Re: C19D062 - 7500 Oakland Ave. Grading Plan

The revised Grading Plan for the above site is attached. We are requesting a review of the attached plan in support of the Site Development Plan and Building Permit of Assisted Living Home. The site is "Tract 2 Block 3, Unit 3 of North Albuquerque Acres" and is located at 7500 Oakland Ave. The review comments have been addressed with the following:

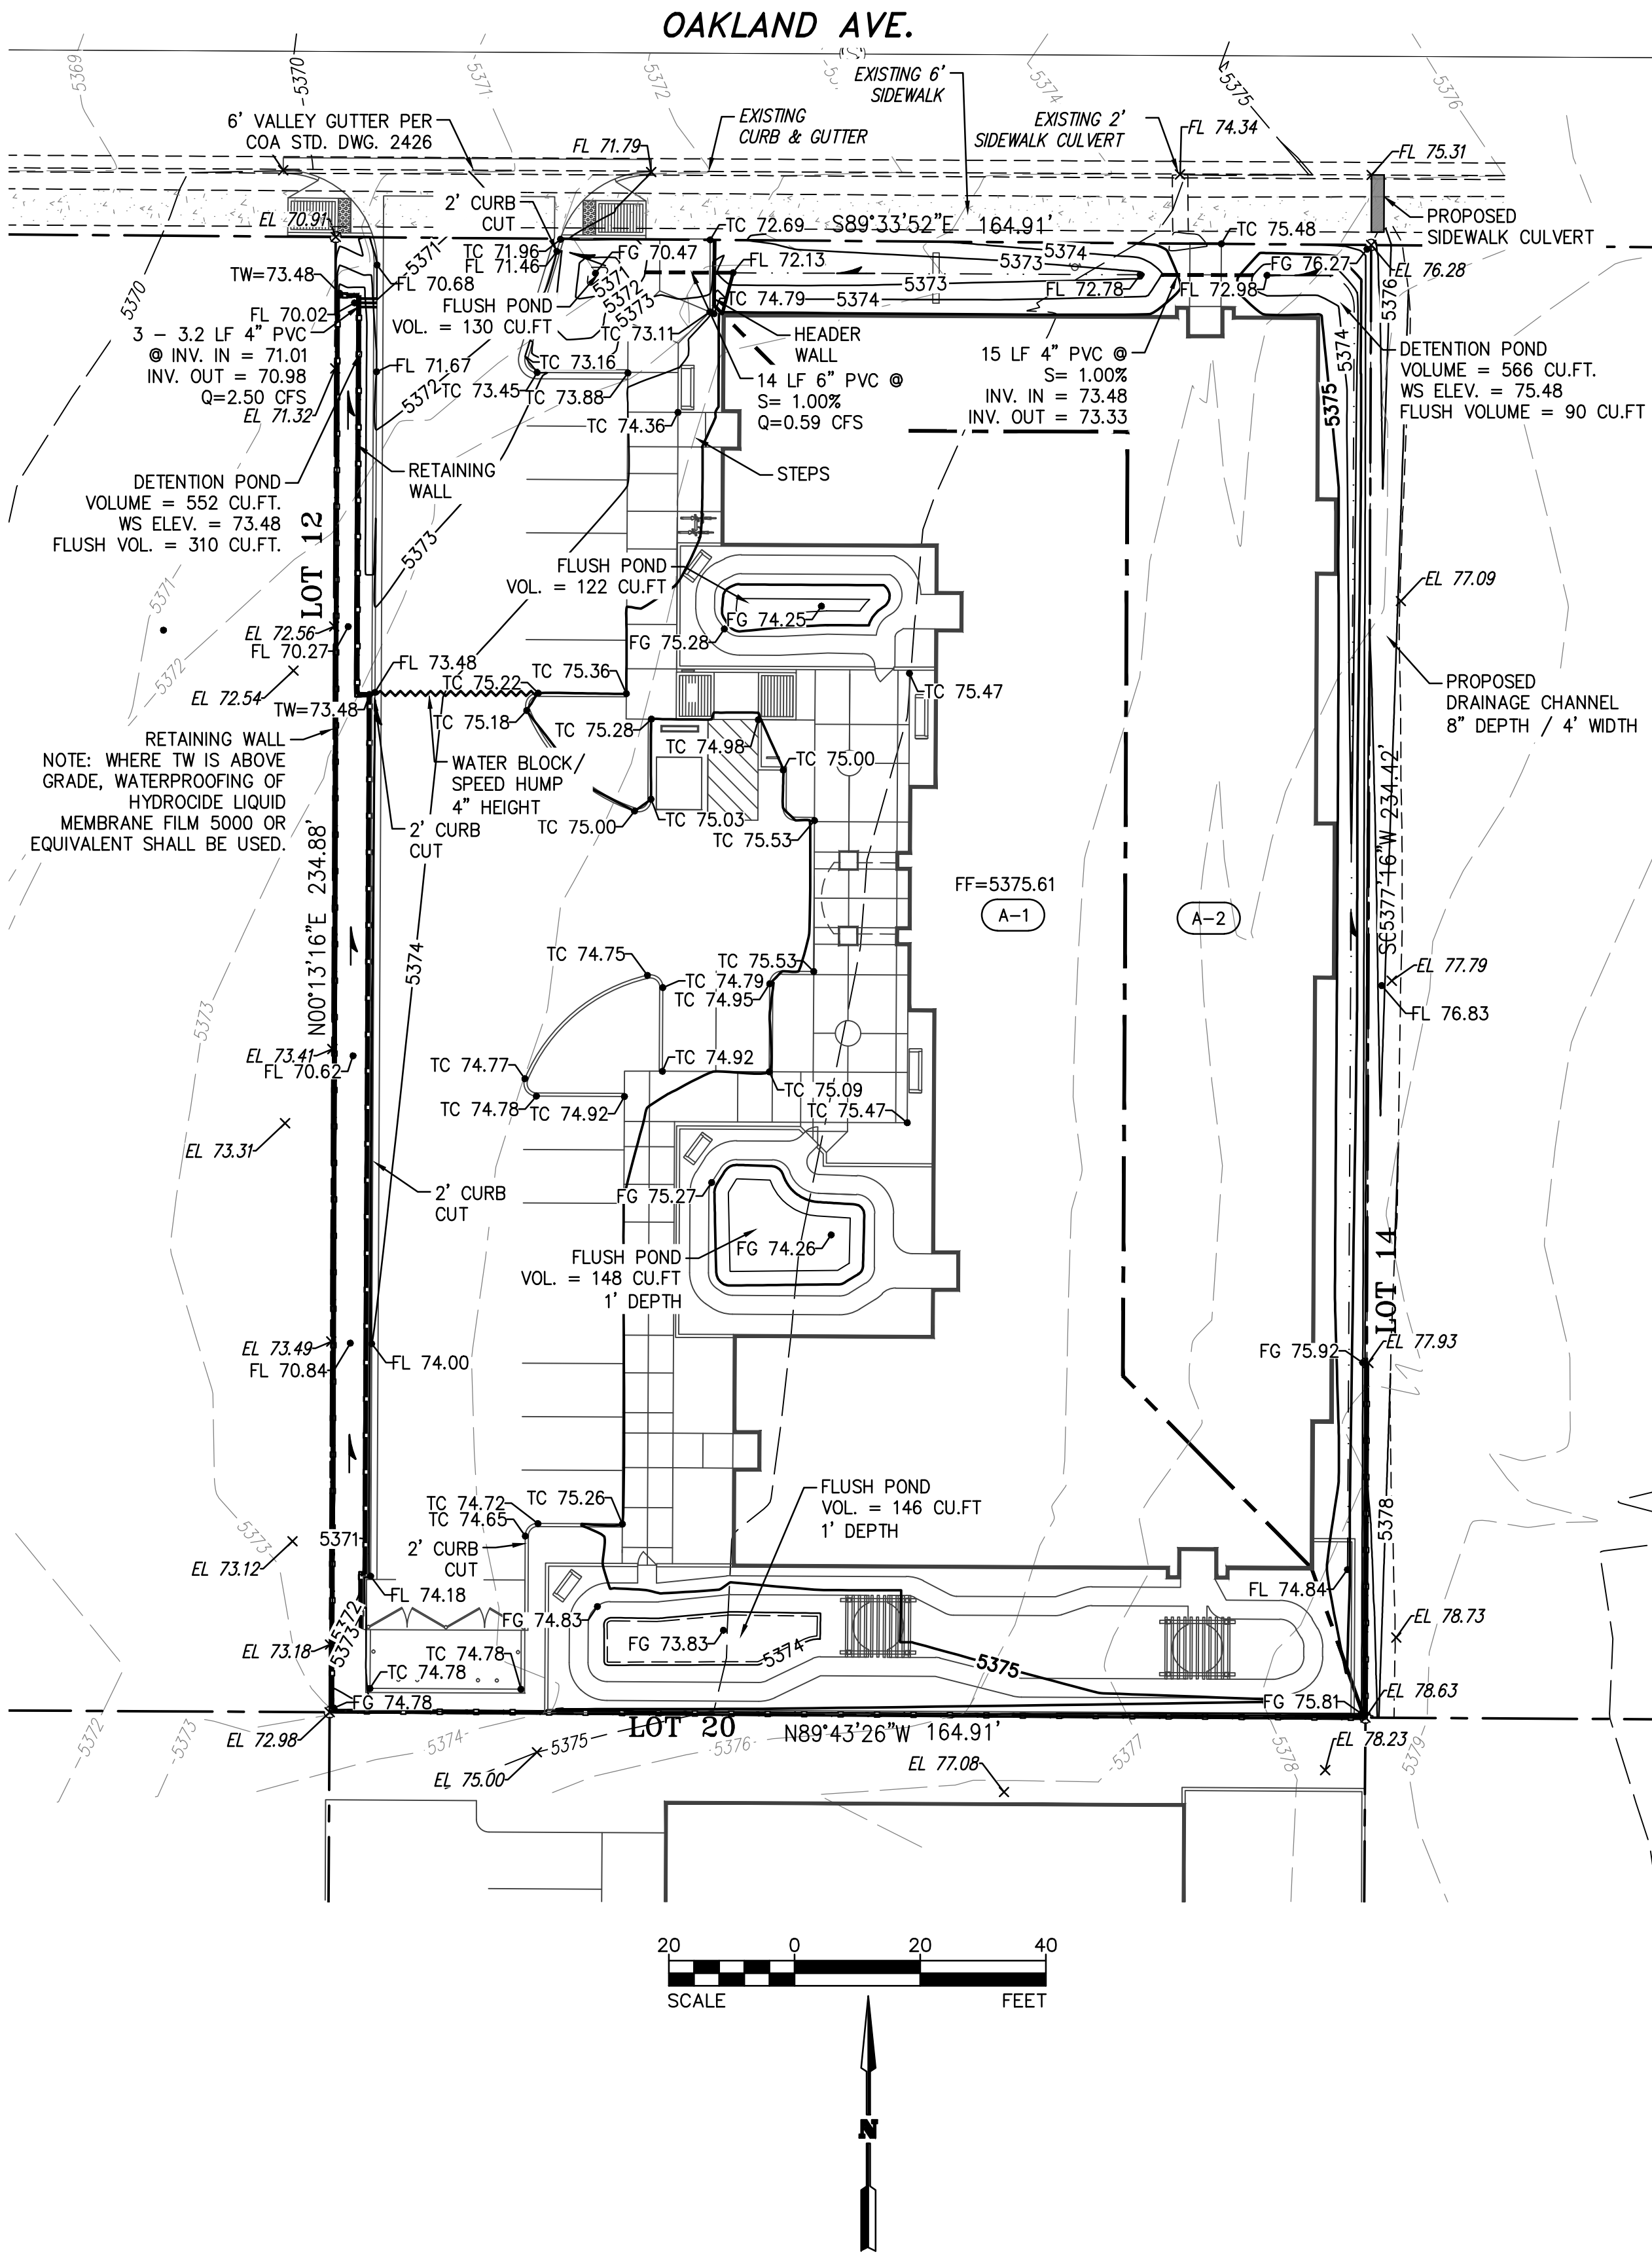
1. The offsite flows have been previously quantified in C19D005 for the church site at 4.41 cfs. A sidewalk culvert will be installed to convey the flows to the street
2. The site to the south is addressed in C19D051 Dental Office. This plan dictates that flows will be directed toward alameda, and existing improvements accomplish this.
3. Detention ponds have been added to control flows to less than the allowable according to the NAADMP.
4. Existing contours are shown.
5. First flush storage calculations and storage volumes are on plan.
